Recommendation Report for Planning Permission for Works or Extension to a Dwelling

REF NO: FP/26/22/HH

LOCATION: 43 Limmer Lane
Felpham
PO22 7HD

PROPOSAL: First floor rear extension.

Proposed Rear Extension
Plans and Elevations
Planning

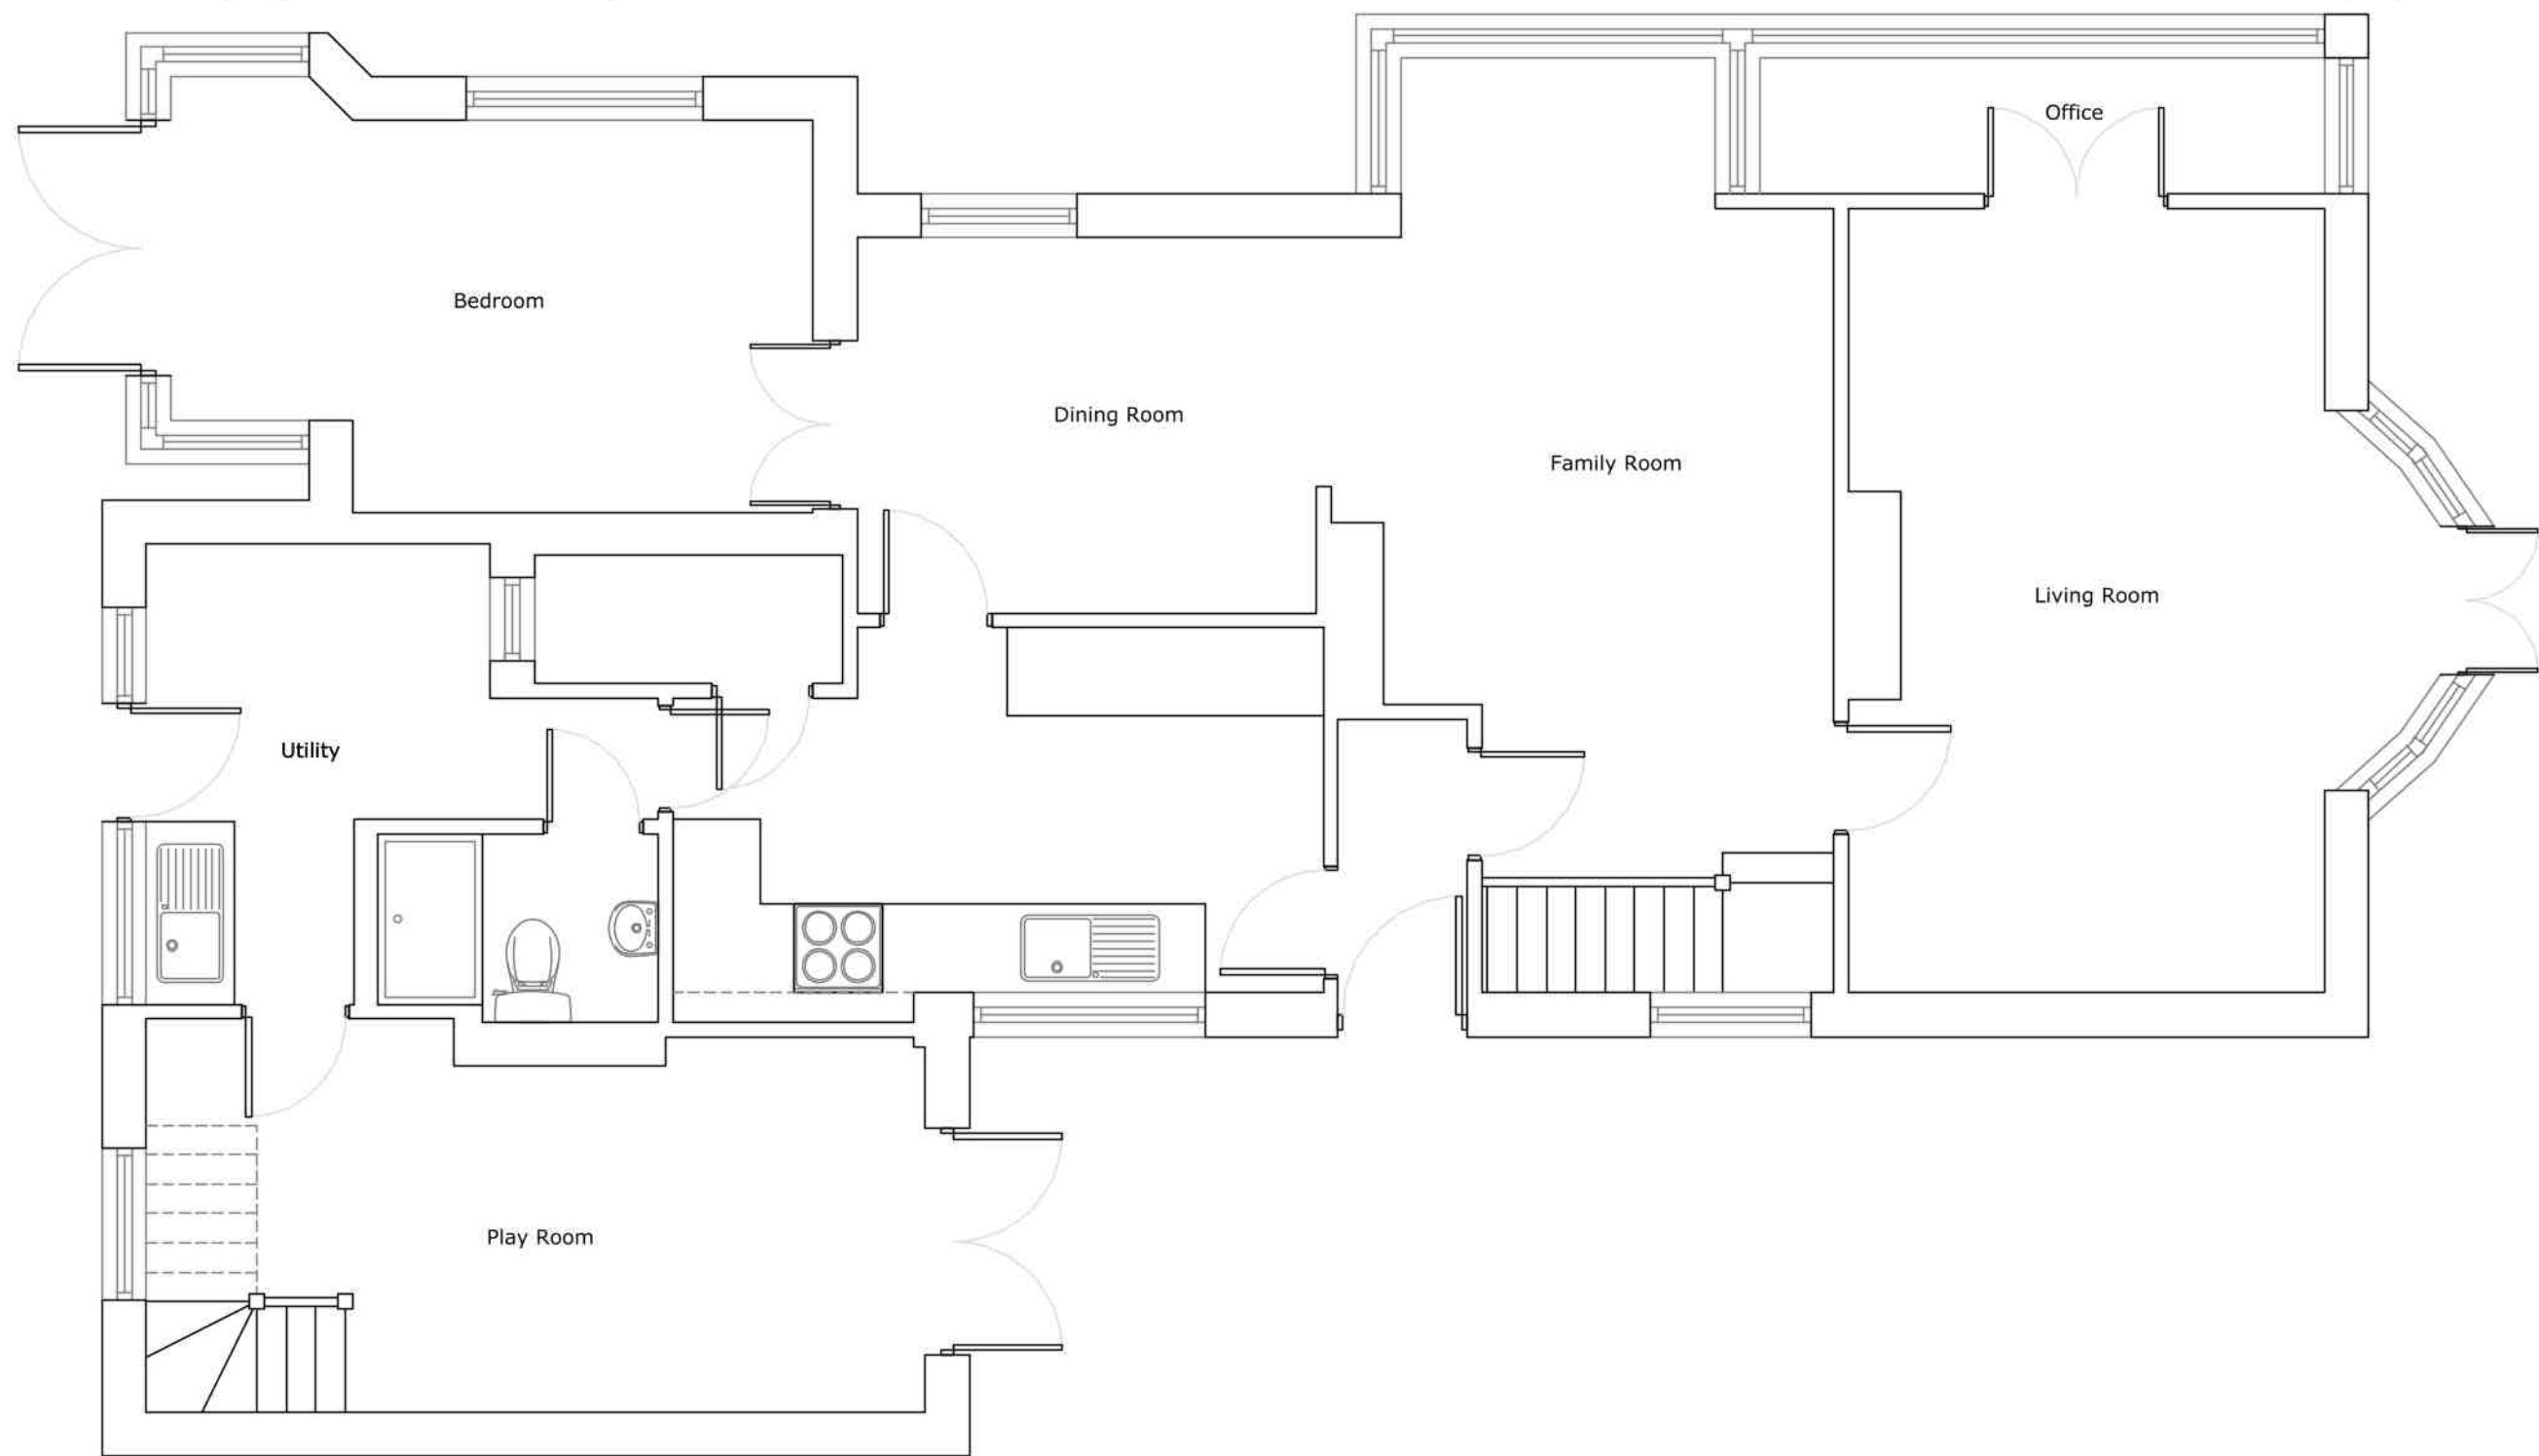
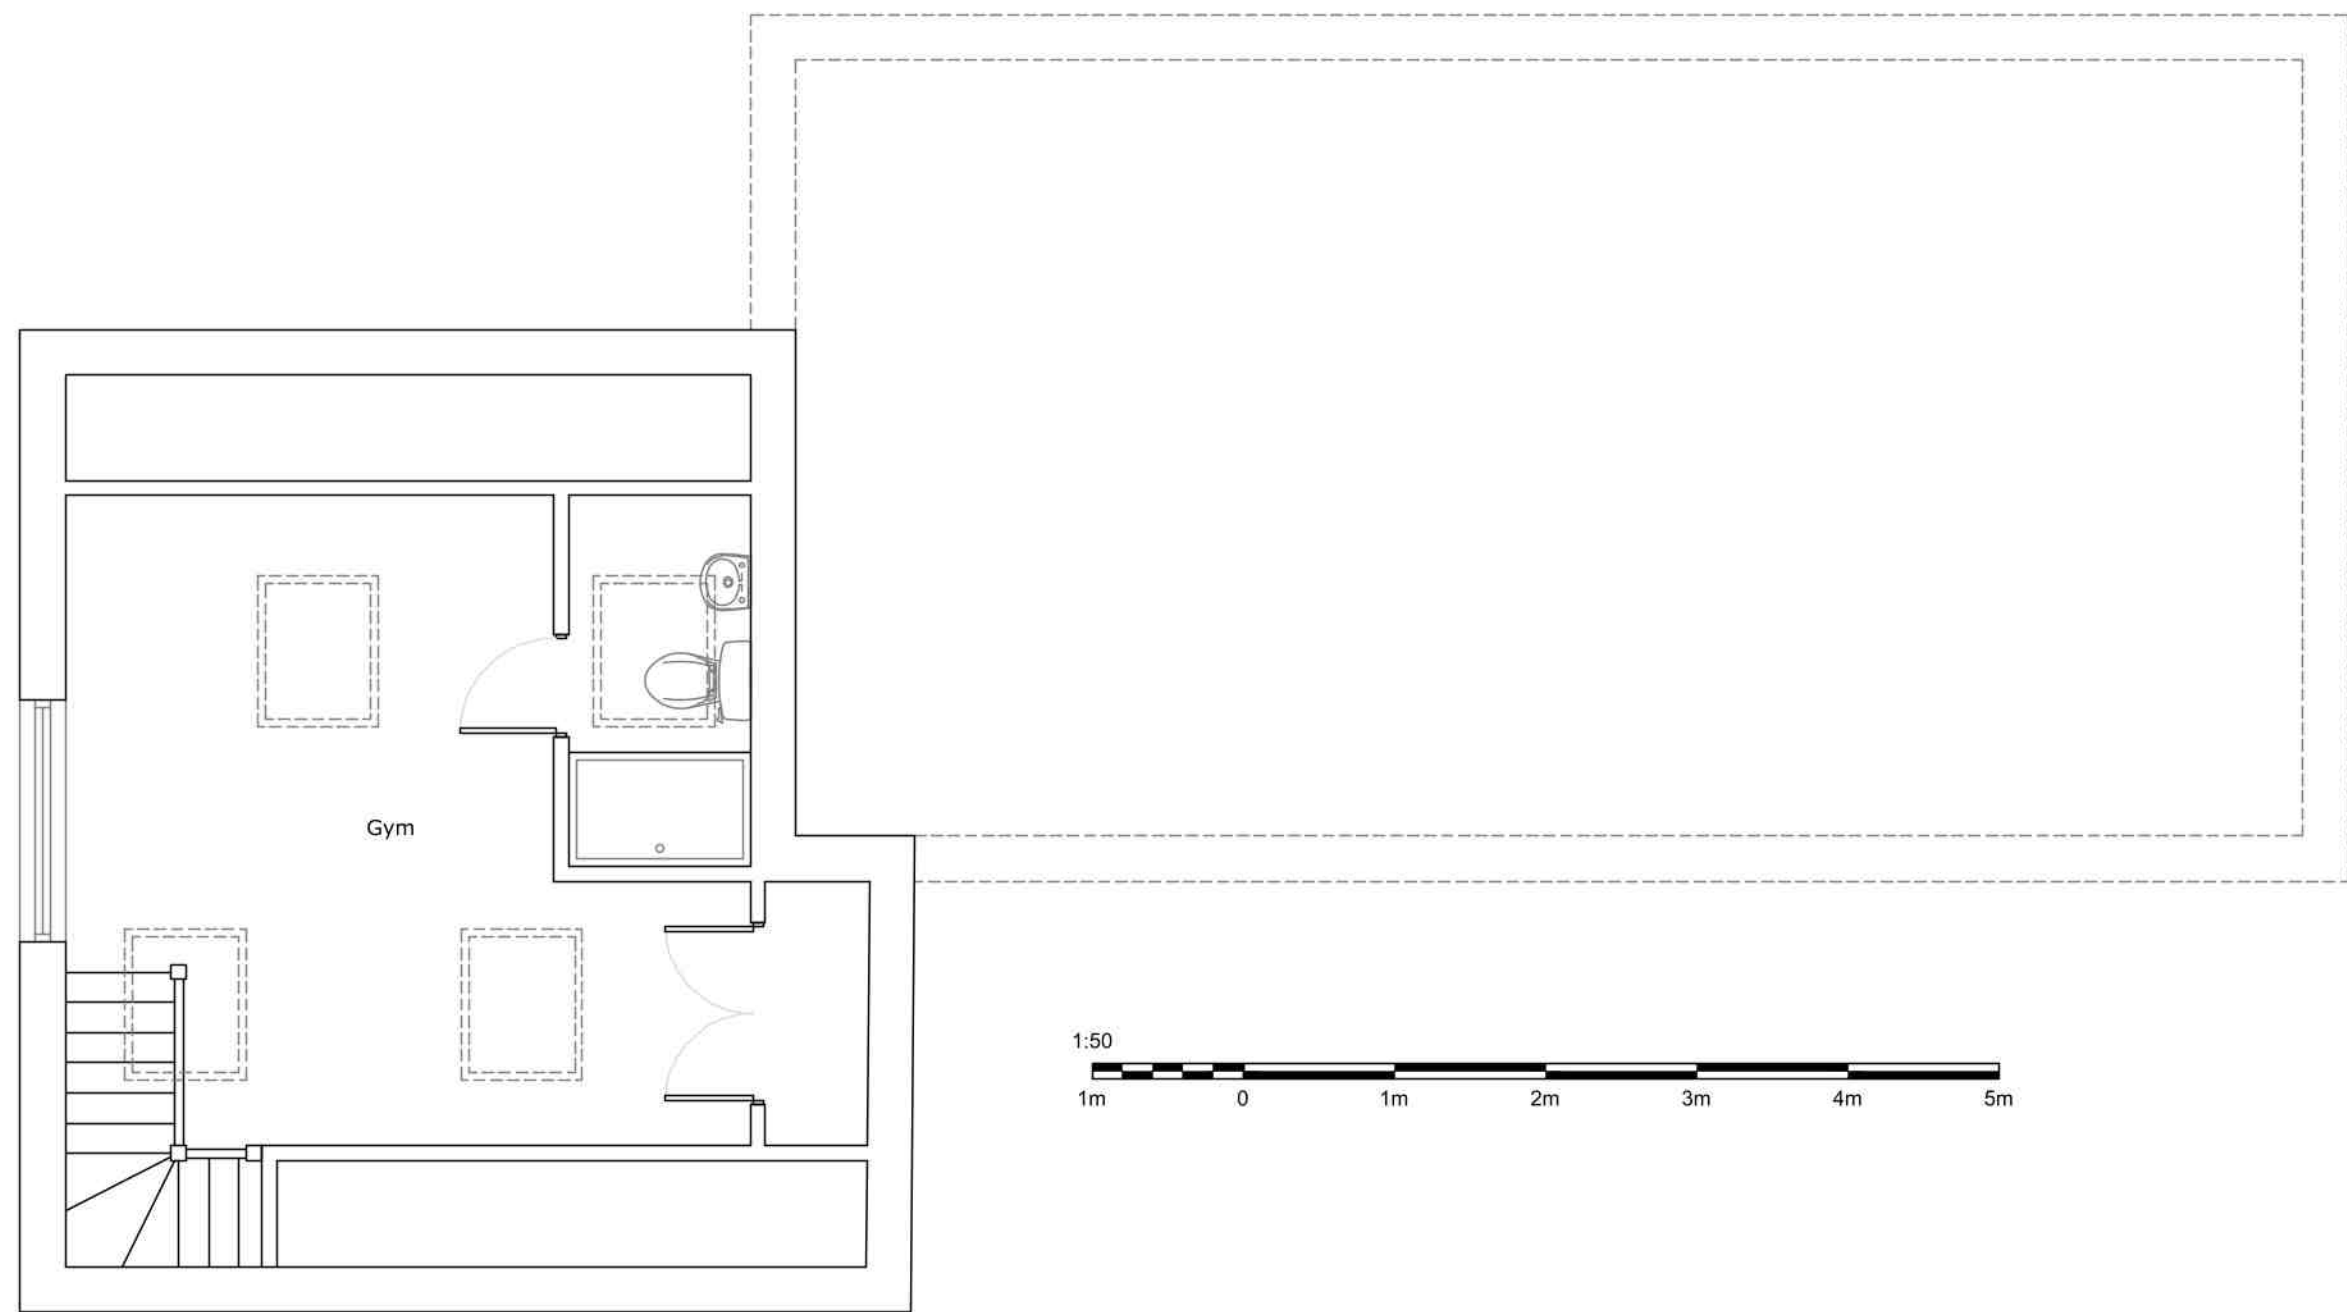
The extension will be on the first floor, and span part of the existing footprint of the dwelling, with a depth of 5.9m and width of 6.48m. It will have a gable roof, matching the design and pitch of the host. This is well integrated with the character of the property and will have minimal impact on visual amenity. The proposal itself is quite tall, but does not unduly overbear on the property, and is appropriate in scale and massing. Although being to the rear, the extension does protrude slightly to the side, and will be visible from points on the street scene. This visibility is limited, and only possible when stood to the front of the property. It retains 26m from the front boundary, and will have insignificant impact on the composition or appearance of the street. The proposal is in keeping with the character of the property, and the locality, and is acceptable.

The proposal will be at first floor level and will have a gable roof at a height of approximately 6.2m, and 2.7m at the eaves. This roof will include the installation of four rooflights, all of which are flush, and will pose little risk of overbearing or overlooking. Around 4m will be retained to the east boundary, 5.8m to the north, and 1m to the west by the proposal. D DM4 (d) of the Local Plan states that any extension or alteration at first floor level should not come to within a minimum of 1m of the side boundary, of which the extension complies with.

Although retaining the existing footprint, the proposal is quite tall, and will result in some overbearing and overshadowing of No.41 to the west and No.45 to the east. However, given the staggered nature of the host and proximity from the neighbouring buildings themselves, this impact will be minimal, and will not be unduly harmful to residential amenity. The proposal is in accord with D DM4 and will not result in unacceptable overbearing or overshadowing of neighbouring properties.

In addition to the rooflights, the extension will feature a set of windows to the north elevation. These windows will overlook the garden of No.16 to the rear but will not directly face the property. As such they pose no risk of significant harm to residential privacy or amenity and are acceptable. This window and
